Letter No. B2/ 5680/94

Sub: MMDA - APV- Construction of 4+3F Residential building in S.no. 94/2 Bk no. 108 of ~~T Nagar~~ with 8 dwellings of door no. 31, DV. Padasivam road. T. Nagar.
Remittance of CD + PF Requested regarding,

SITE PLAN
SCALE: 1:200

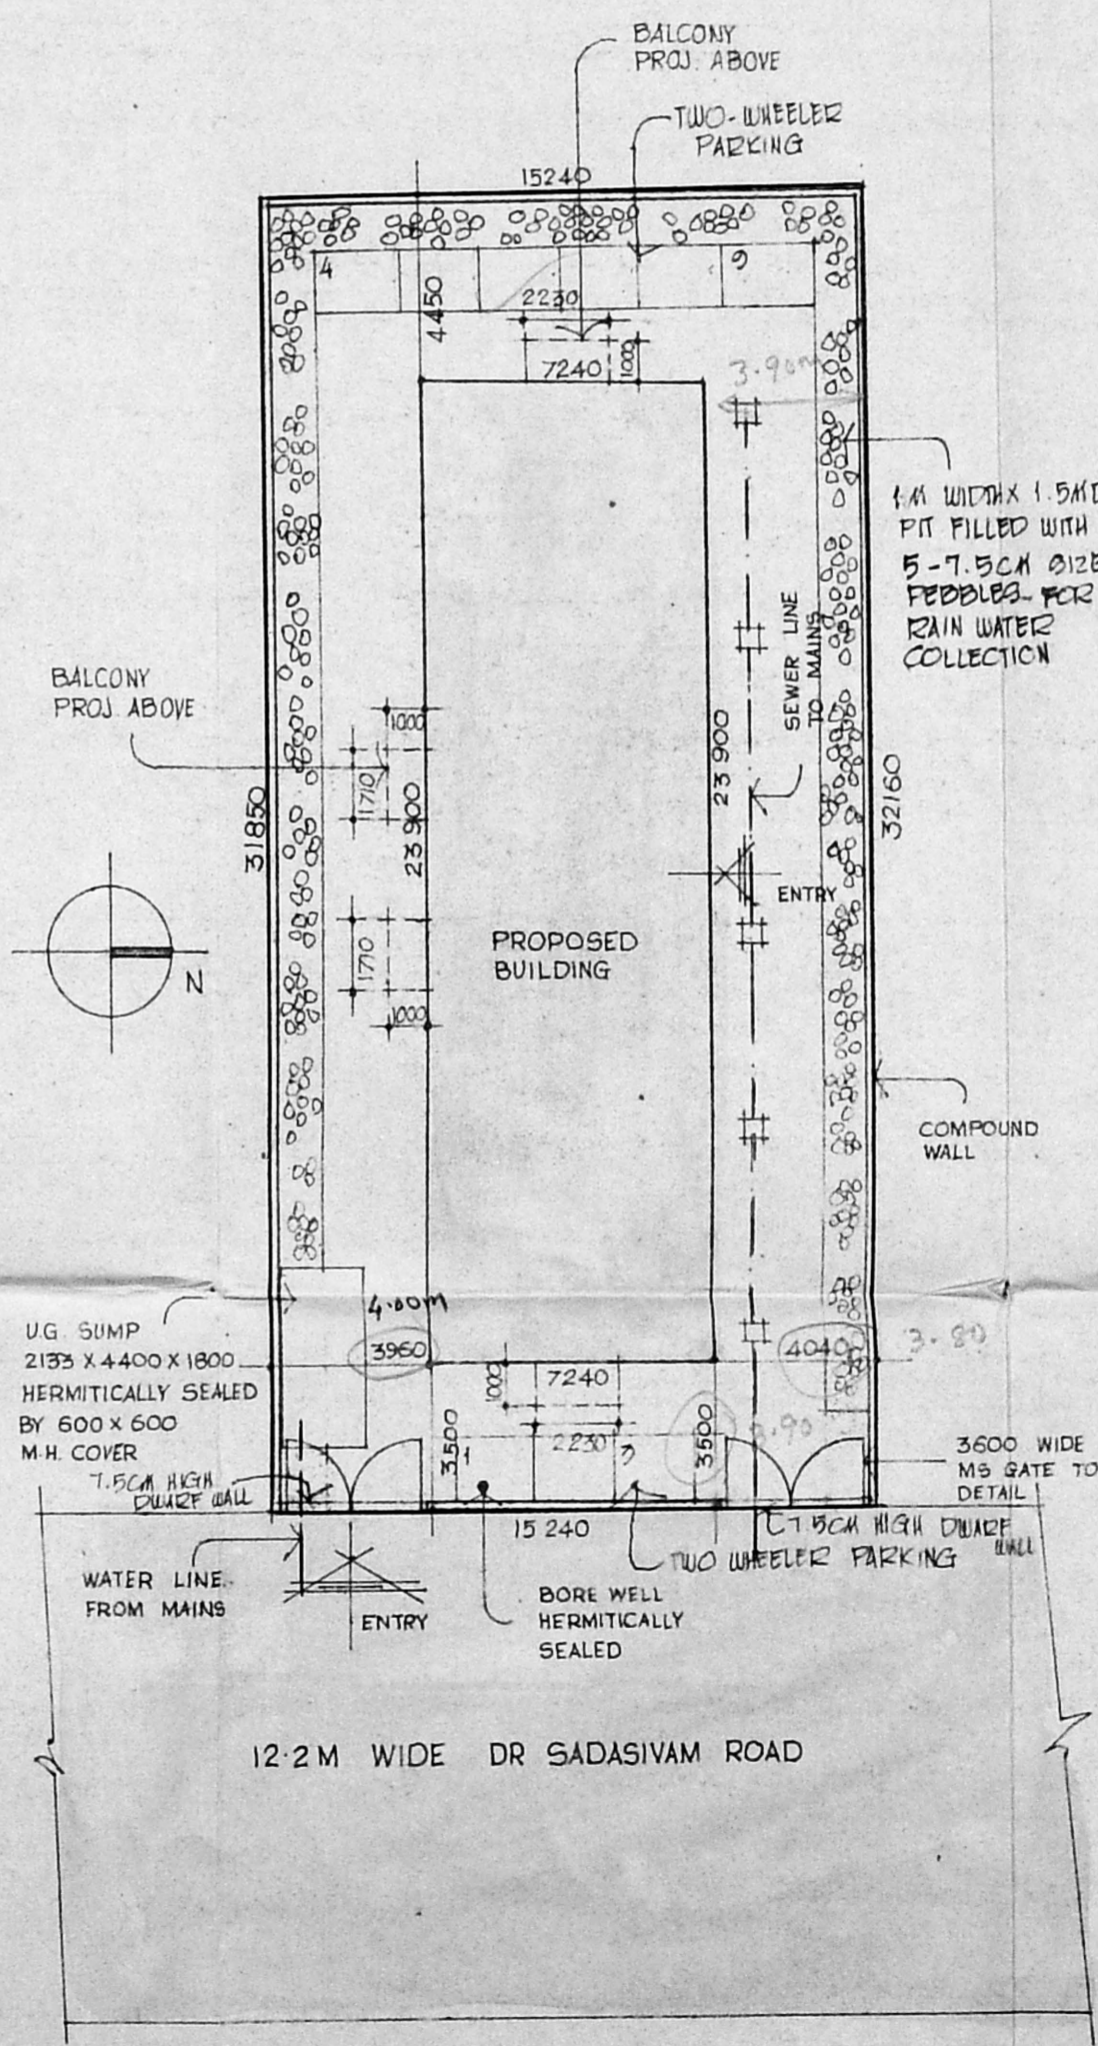
- (d) RP showing the Balcony projections in site plan.
- (e) Original Planning permit and Appd plan in 1993, (f) IB vide no. 5/11/94 MDA
5. The issue of Planning Permission will depend on the compliance/fulfilment of the conditions/payments stated above. The acceptance by the Authority of the Prepayment of the Development charge and other charges etc. shall not entitle the person to the Planning Permission but only refund of the Development charge and other charges (excluding Scrutiny Fee) in cases of refusal of the permission for non-compliance of the conditions stated above or any of the provisions of DCR, which has to be complied before getting the planning permission, or any other reason, provided the construction is not commenced and claim for refund is made by the applicant.
